MECKLENBURG COUNTY  
Park and Recreation Department

MEMORANDUM

**RE:** Rezoning Petition #2021-033 Charlotte Pipe and Foundry Company Rezoning

RZ-1.0

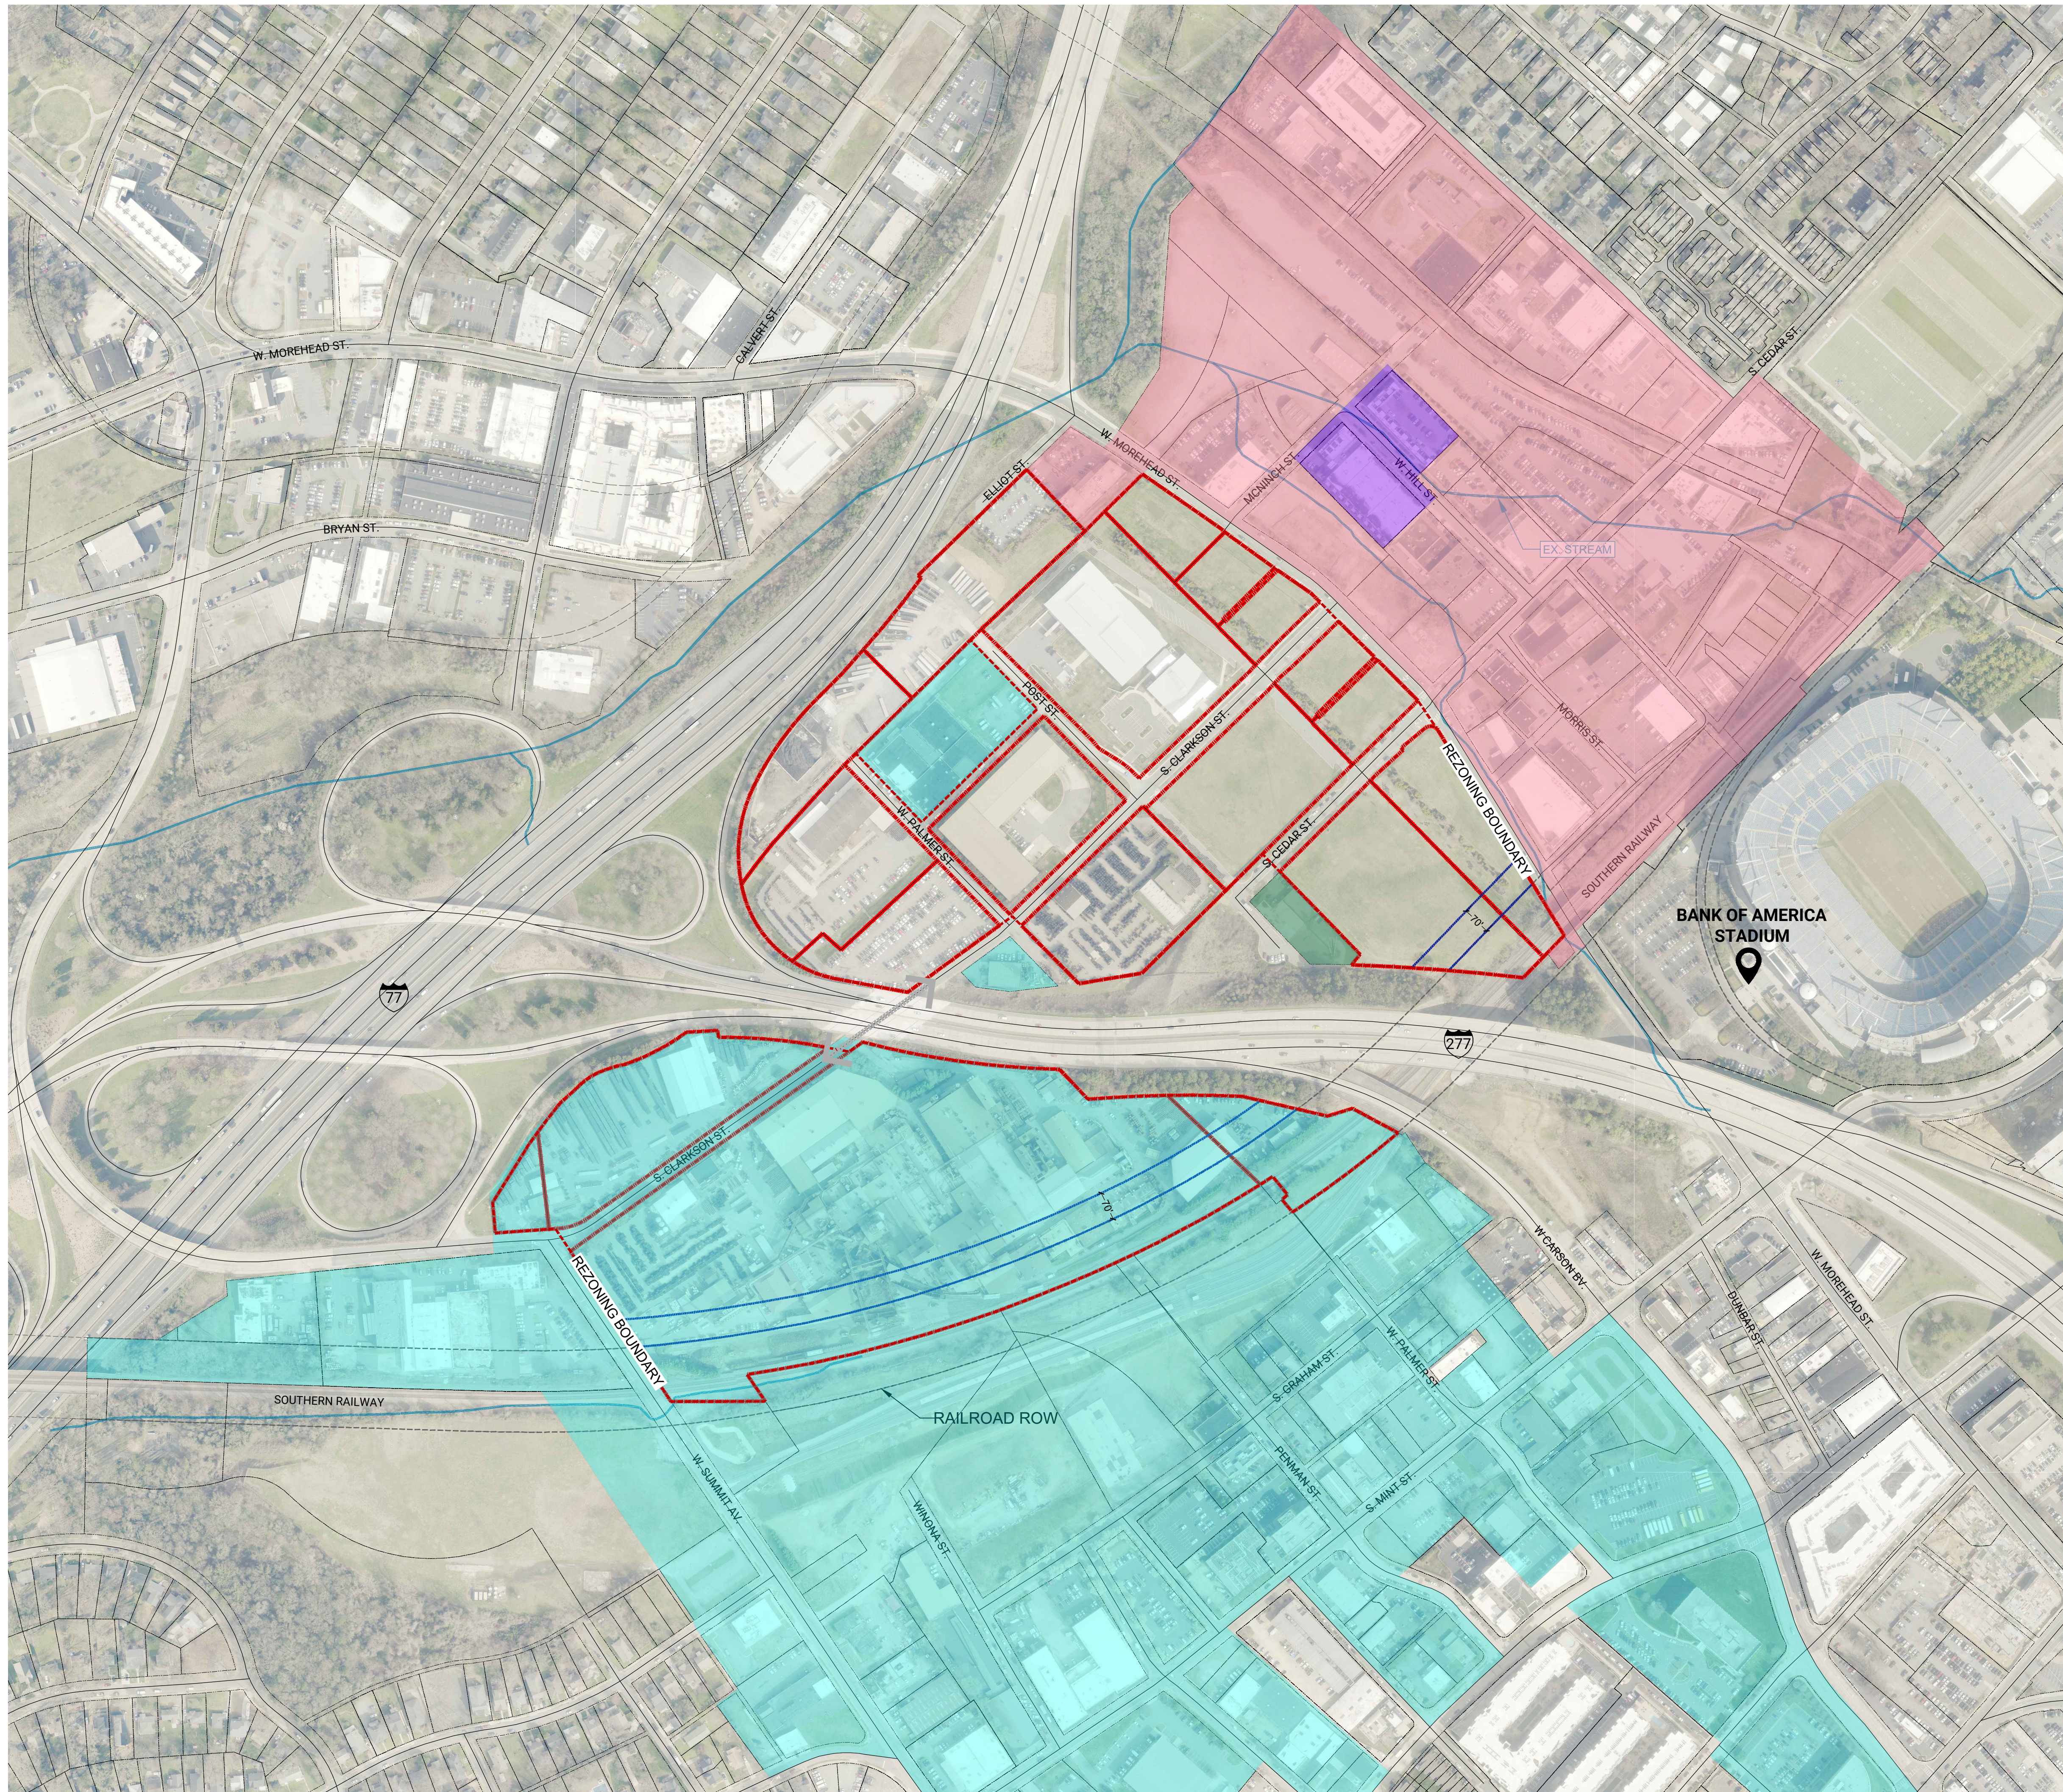
MCPR requests a minimum of 2 acres to be dedicated and conveyed to Mecklenburg County for a future neighborhood park. This requested park land shall be adjacent to a public right-of-way for access and is conducive for the development of the typical amenities found in a neighborhood park and can not include tree save parcels. Contact MCPR with any questions/comments.
